City of Albuquerque Stormwater Construction Site Inspection Report

ESC File No.	P09E002G	Project Name:	Ceja Vista Senior Apartments		
NPDES Id. No.	NMR10032D	Location:	10001 Ceja Vista Rd. SW		
6/4/2021	Owner	Contractor			
Operator	DBG Properties, LLC		Trevco, Inc.		
Contact name & title	Todd Coleman		Trevor Wismann		
e-mail	todd@dbgpropertiesllc.com		Trevor@Trevco-inc.com		
Contact Phone #	505-269-7481		505-238-6215		
COA Inspector	Thomas Evans		Start/End Time:	9:55 AM-10:40 AM	
Construction Phase:	Vertical				
Type of Inspection:	Regular	Storm Event	Past Storm Event >0.25"	311/Complaint	Follow Up
Weather at time of inspection?	clear		Temperature:	~ 76	
Estimated date of last storm 0.25" or greater	5/31/2021

**SITE WILL HAVE A SILT FENCE PERIMETER WITH INLET PORTECTION FOR ACTIVE INLETS. SITE DRAINS TO AN OFFSITE POND.**

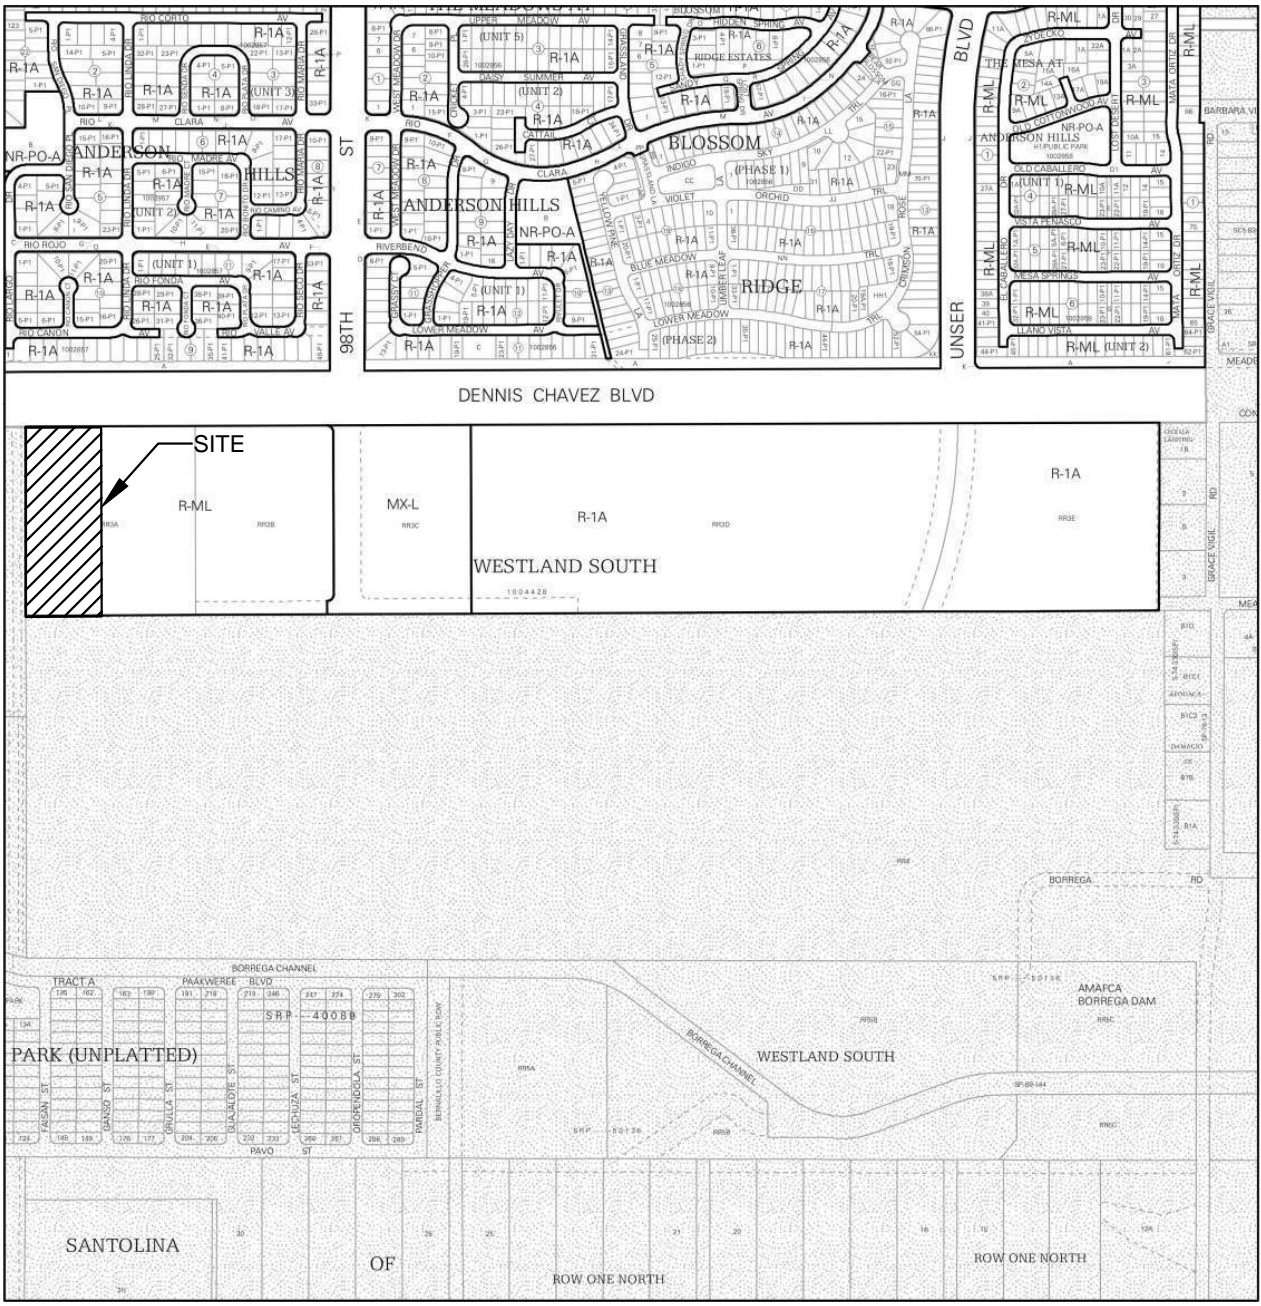
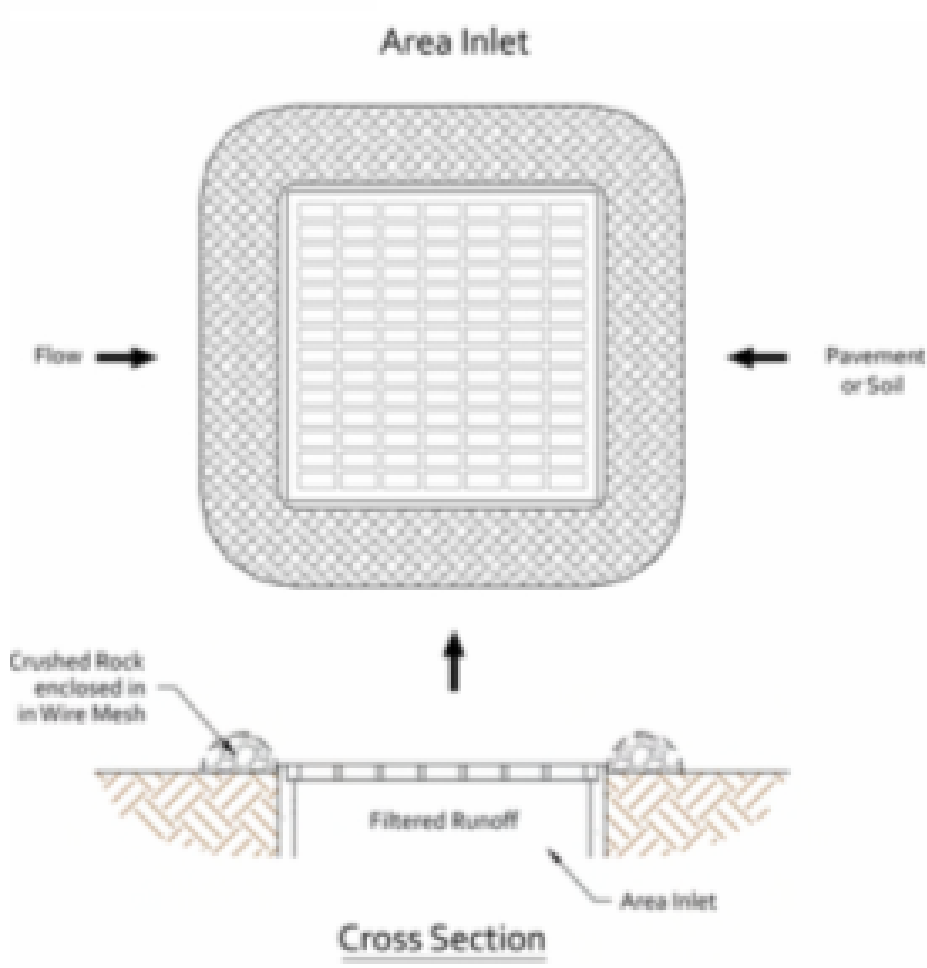
Item Number	Deficiency/ Corrective Action				
1	Track-out pad needs maintenance. Modify track-out pad to prevent additional sediment from exiting the site and remove accumulated sediment.,				
2	Sediment blowing onto adjacent property. Add additional sediment control BMP (silt fence) along East wall to achieve the minium height of 2 feet above grade.				
3	Significant erosion at SE corner of site. Install stabilized construction entrance per the ESC Plan.				
4	Hole in silt fence at North perimeter. Repair and maintain silt fences.				
5
